# CITY OF ALBUQUERQUE

May 23, 2019

**Re: O'Reilly Auto Parts  
6830 Coors Blvd NW  
30-Day Temporary Certificate of Occupancy  
Transportation Development Final Inspection  
Engineer's/Architect's Stamp dated 5-20-19 (E12D006G)  
Certification dated 5-20-19**

Project Number 2017004
Drawn By RC
Checked JW
Issue Date September 20, 2017
Site Plan for Building Permit

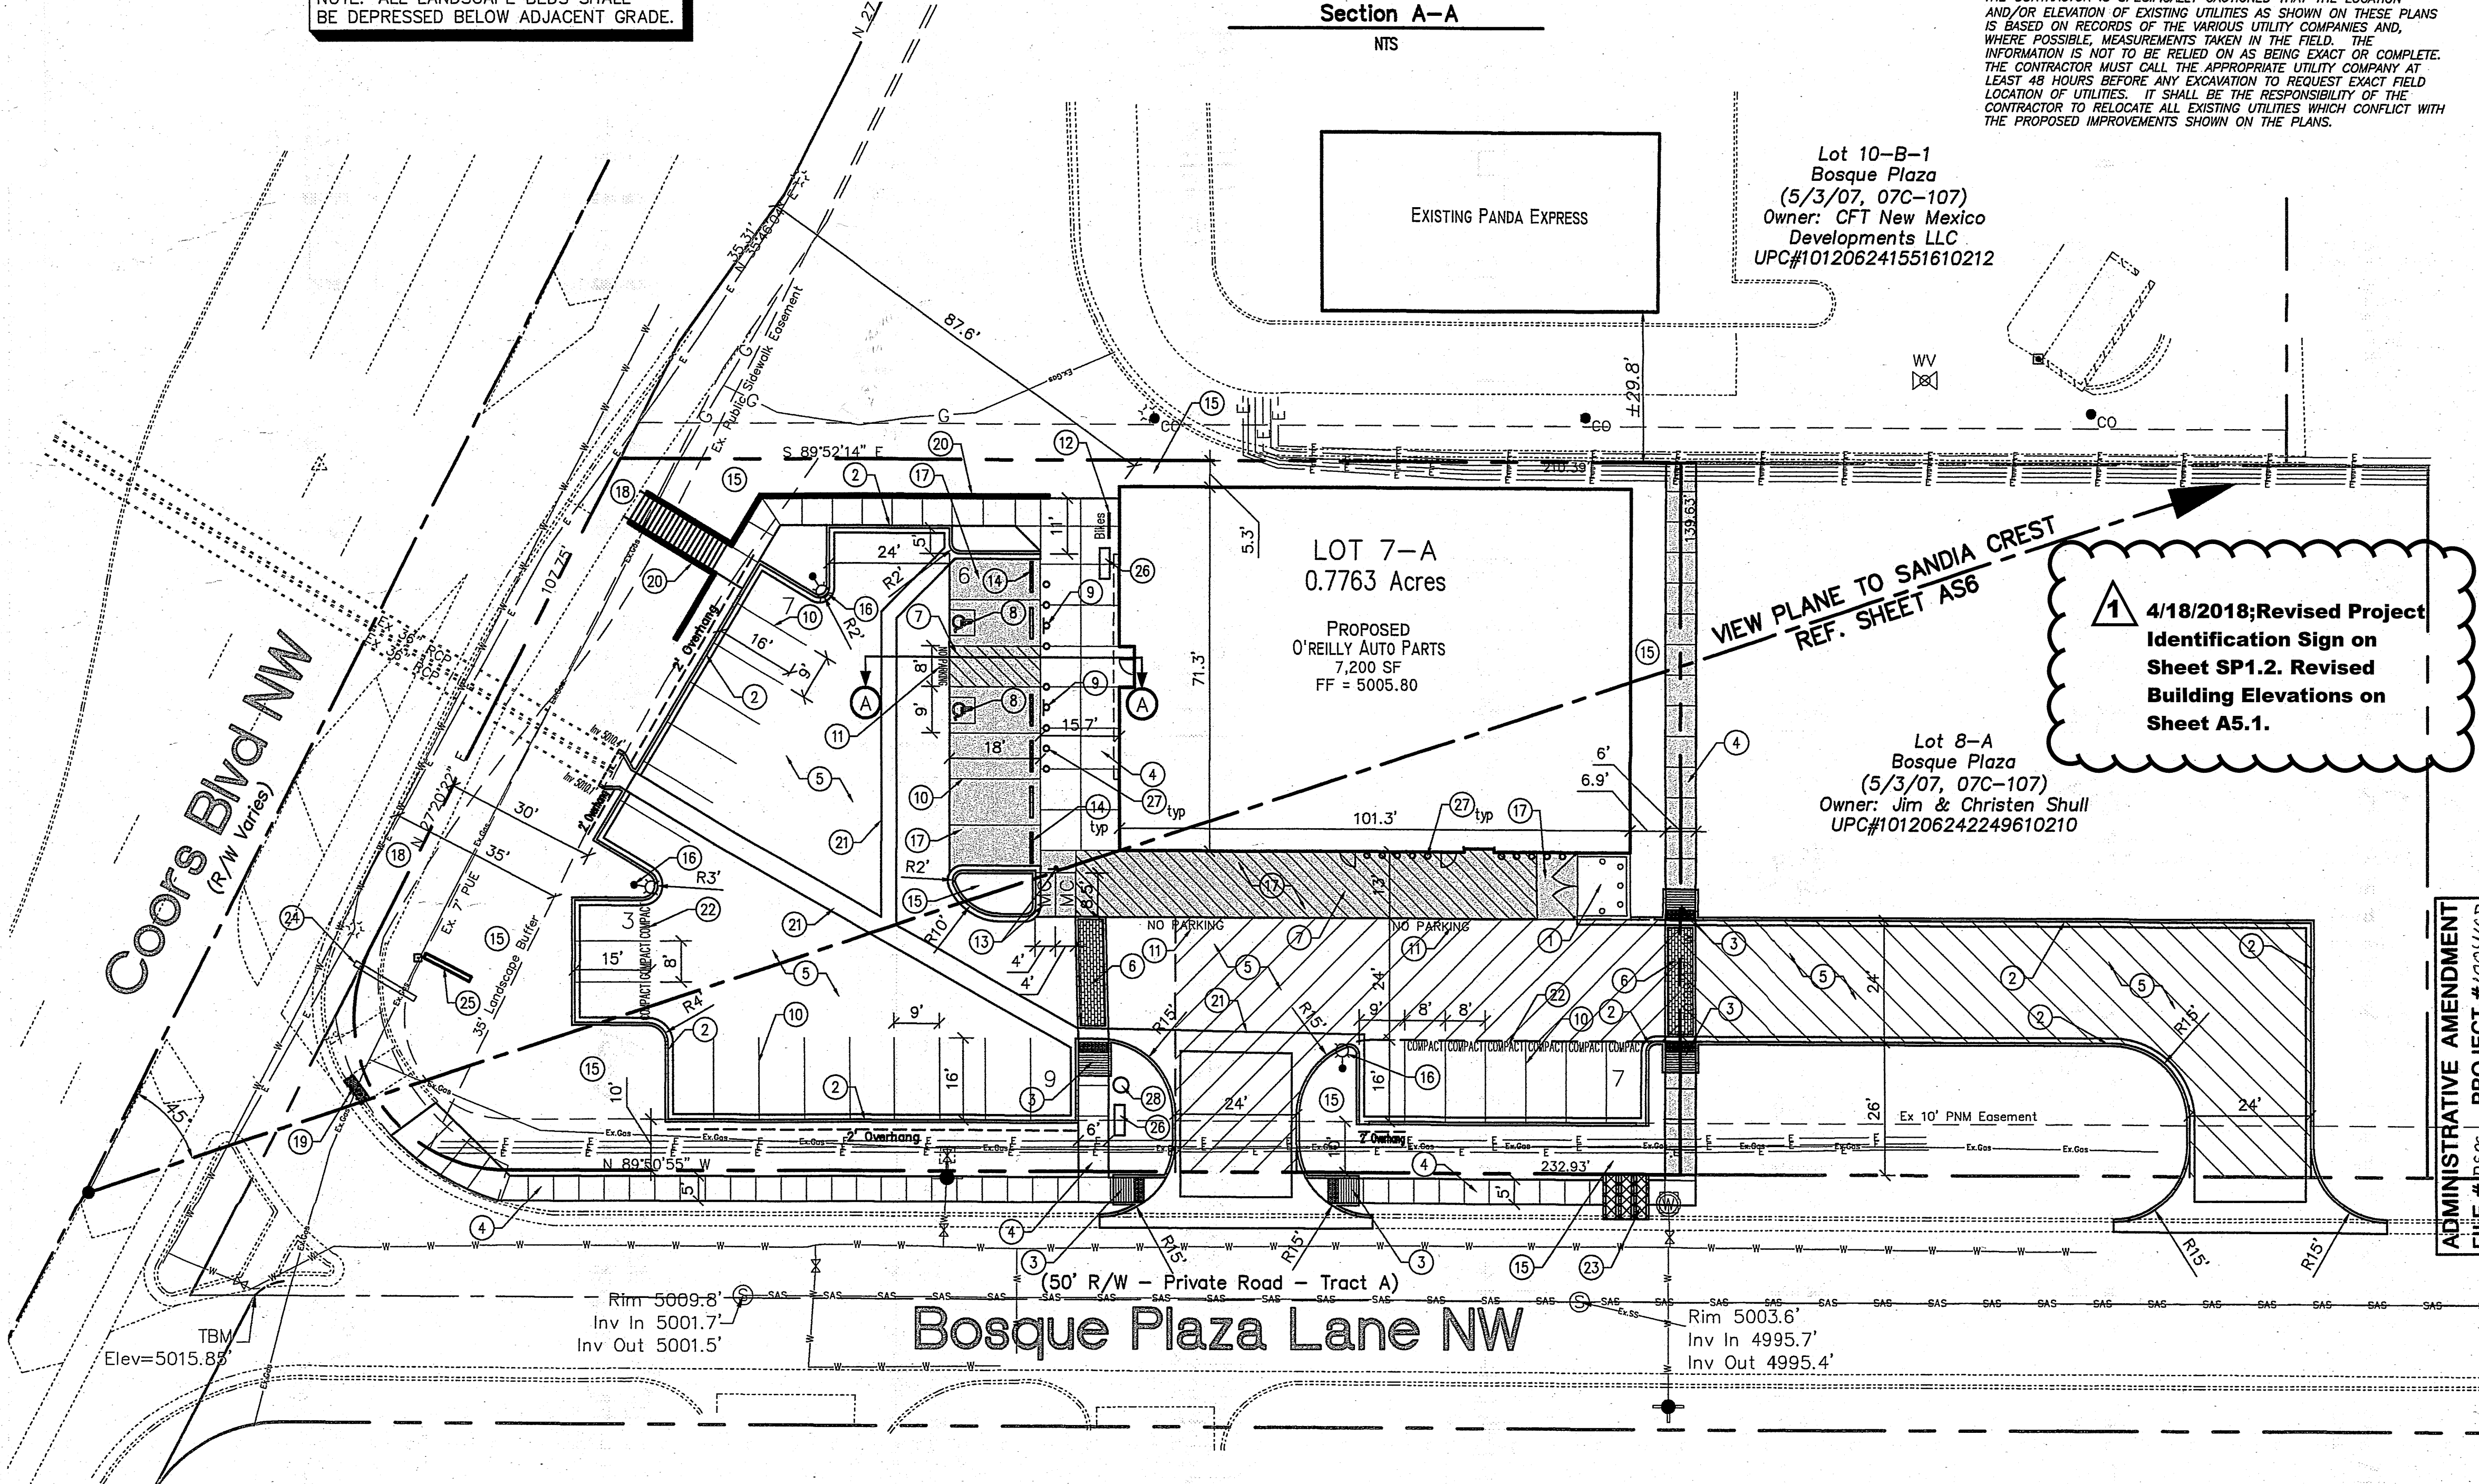
1. Please add missing Truncated Domes. (See approved plan)
2. Please add motorcycle signs.
3. Please paint COMPACT to the parking stalls as indicated on approved plan.
4. Please send photos of corrections to [epgomez@cabq.gov](mailto:epgomez@cabq.gov)
